## Department of Transportation

RE: Grandview Reserve Sketch Plan - EA2020

- CDOT Hydraulics Engineer has reviewed the Master Development Drainage Plan dated August 2020 by HR Green Development, LLC. and their comments are as follows:

PROPOSED DR1

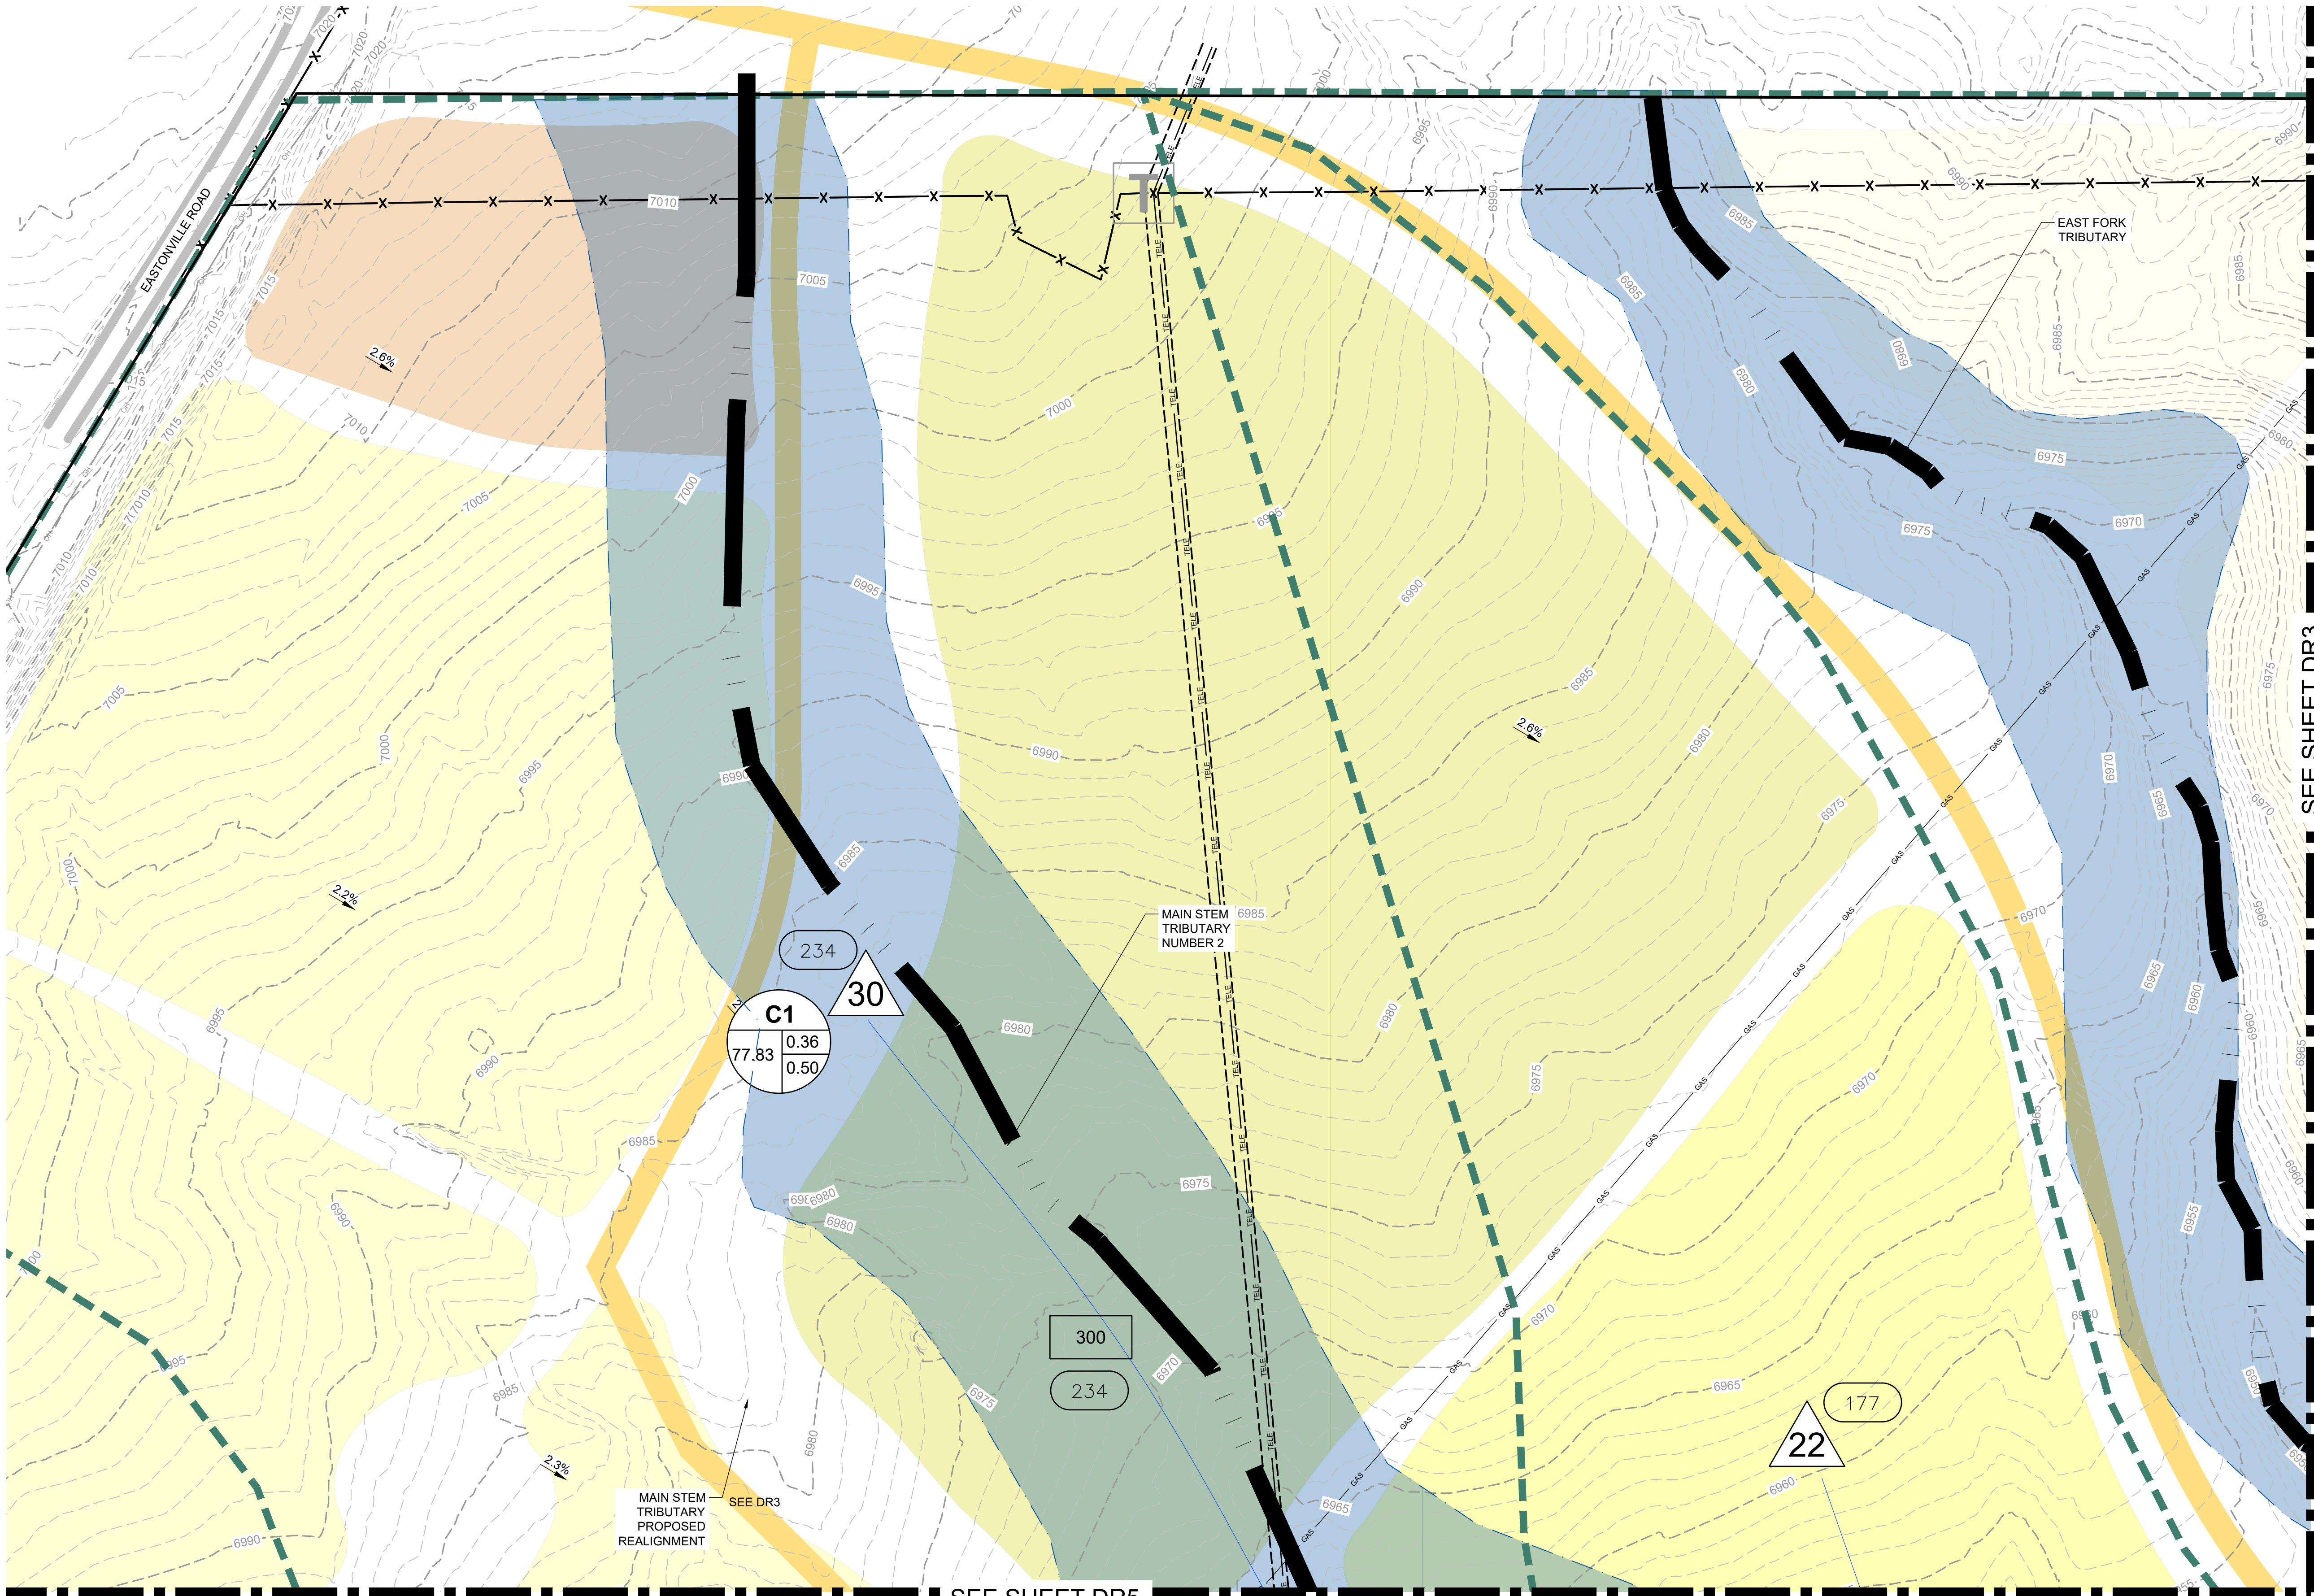
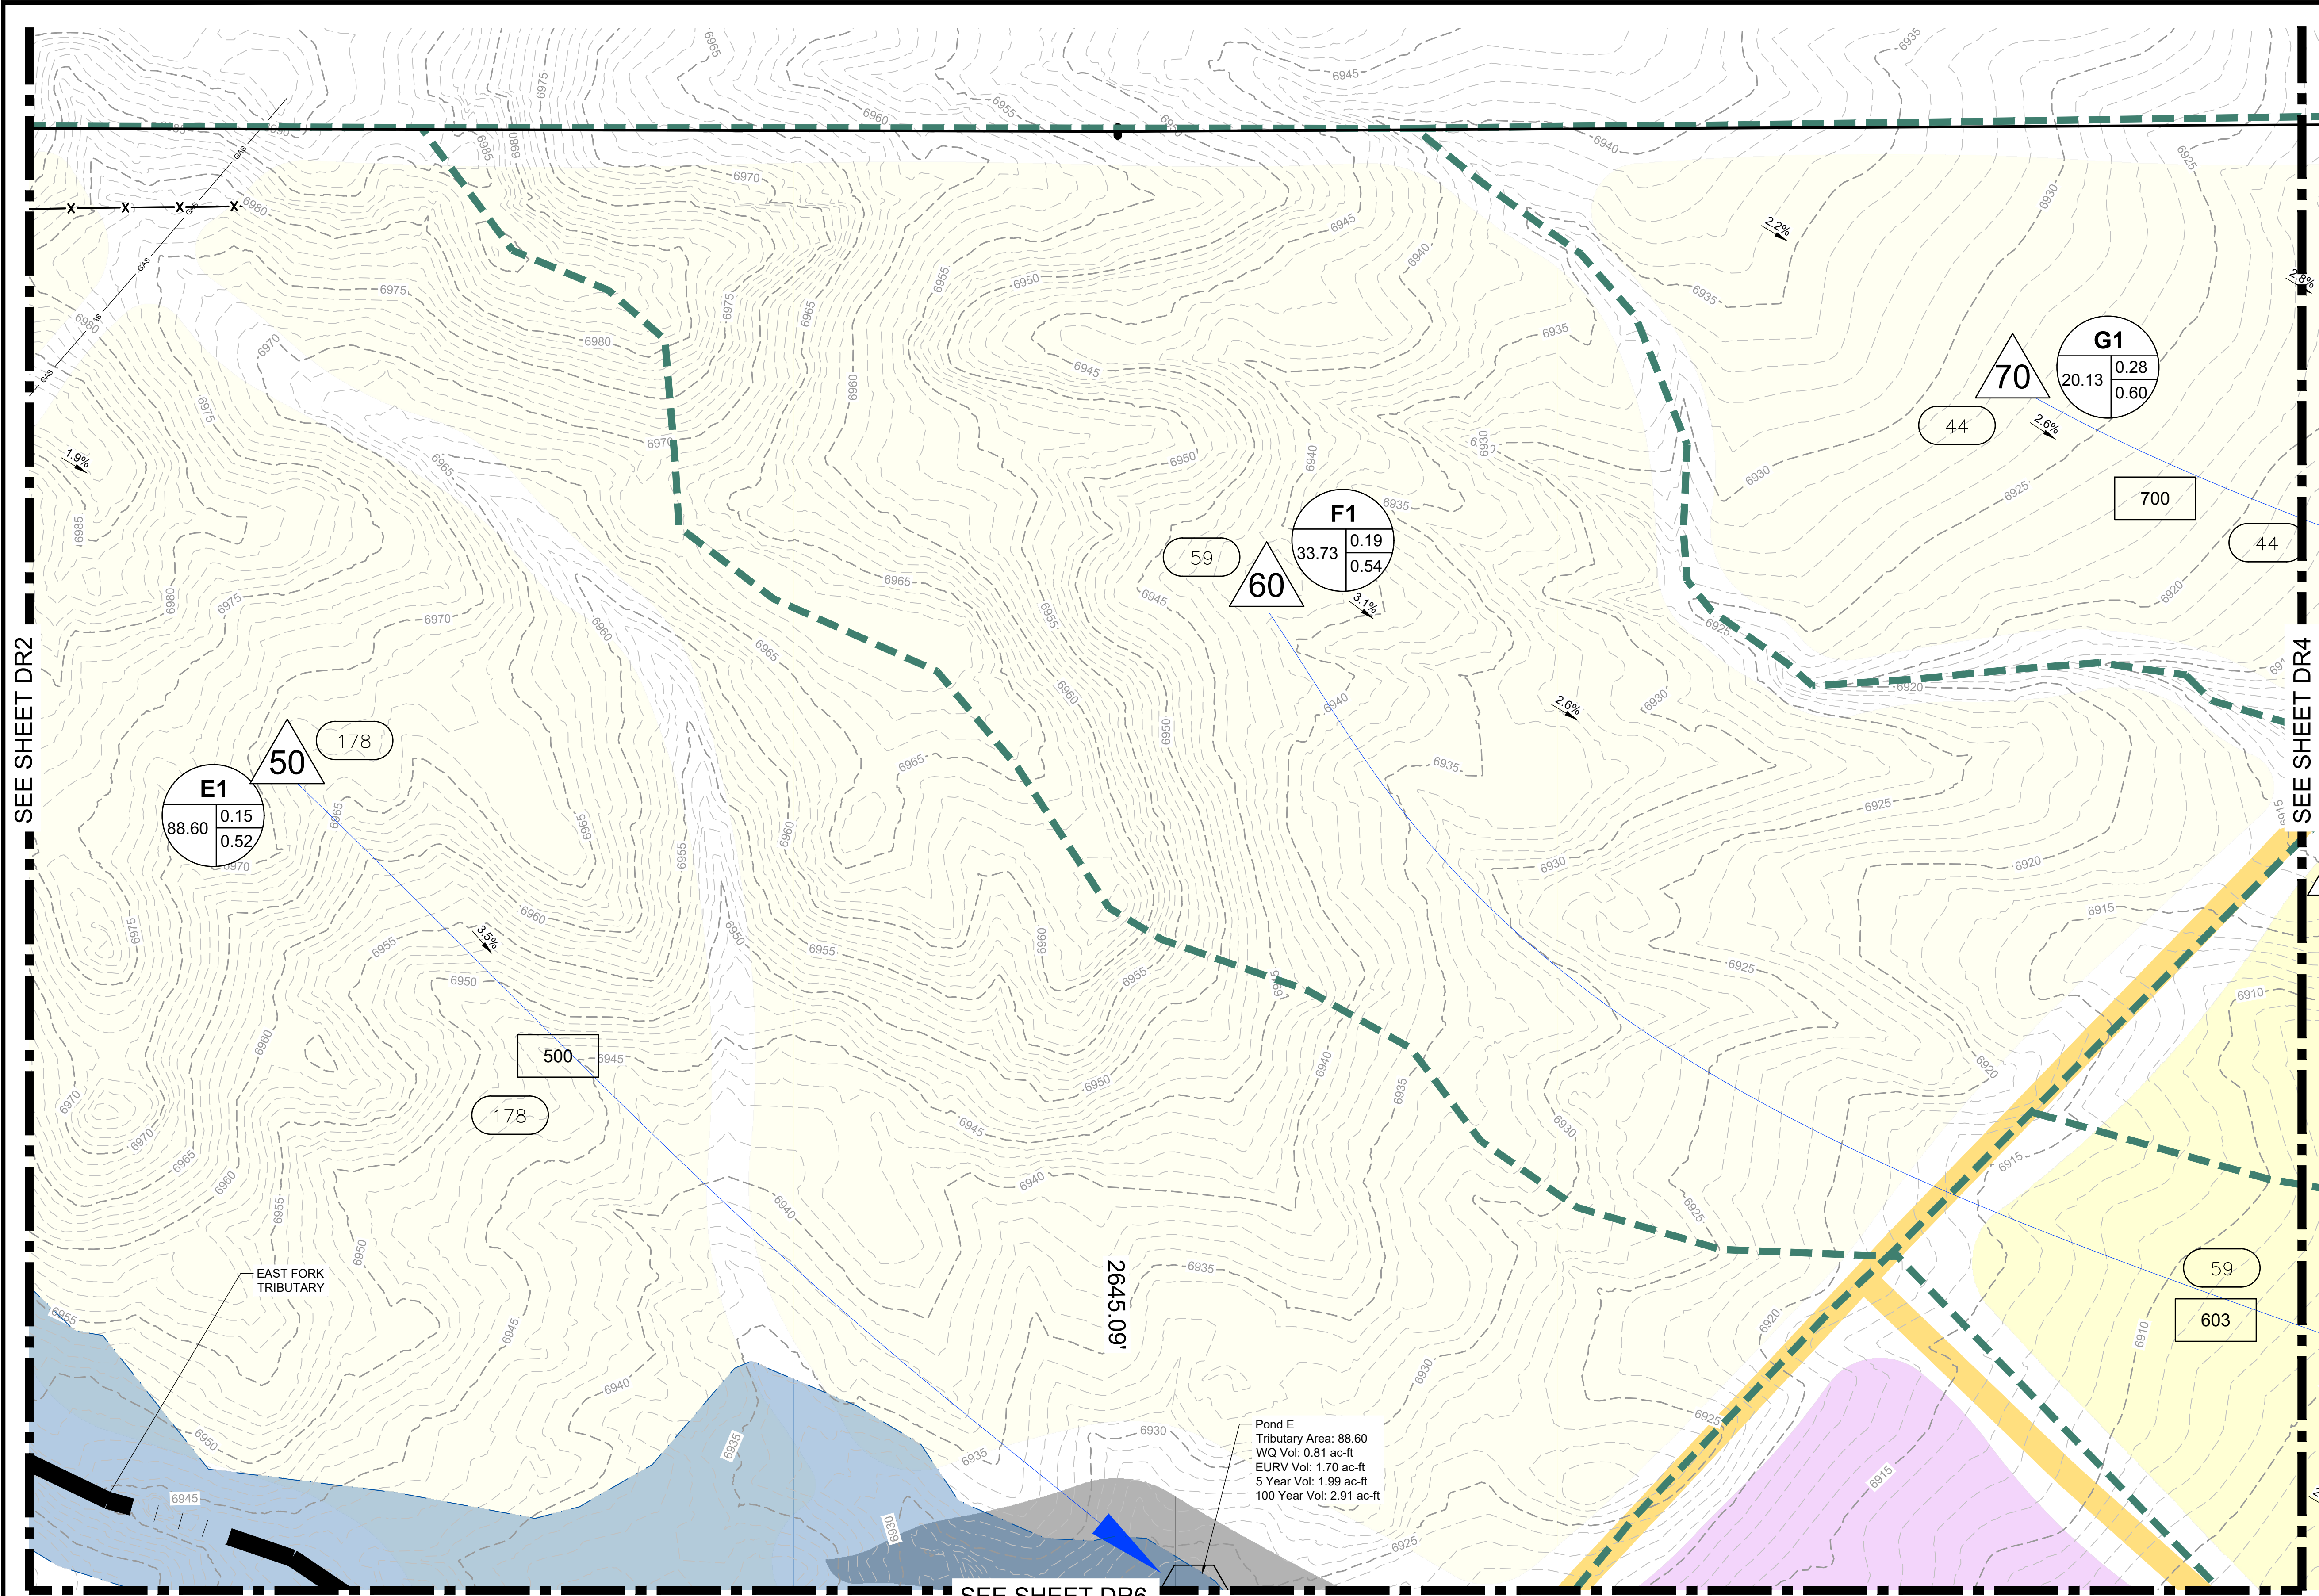
- c) Revise land use legend to accurately reflect the colors in the maps.
  - d) Almost all of the EDBs encroach in the floodplain. This will need FEMA approval (CLOMR/LOMR) along with the channel work.

- e) Given that this is an MDDP, more detail should be provided for the channel modifications to better understand impacts. Provide a grading plan or at the very least a typical cross section of the proposed channel improvements, locations for proposed grade control structures, etc.
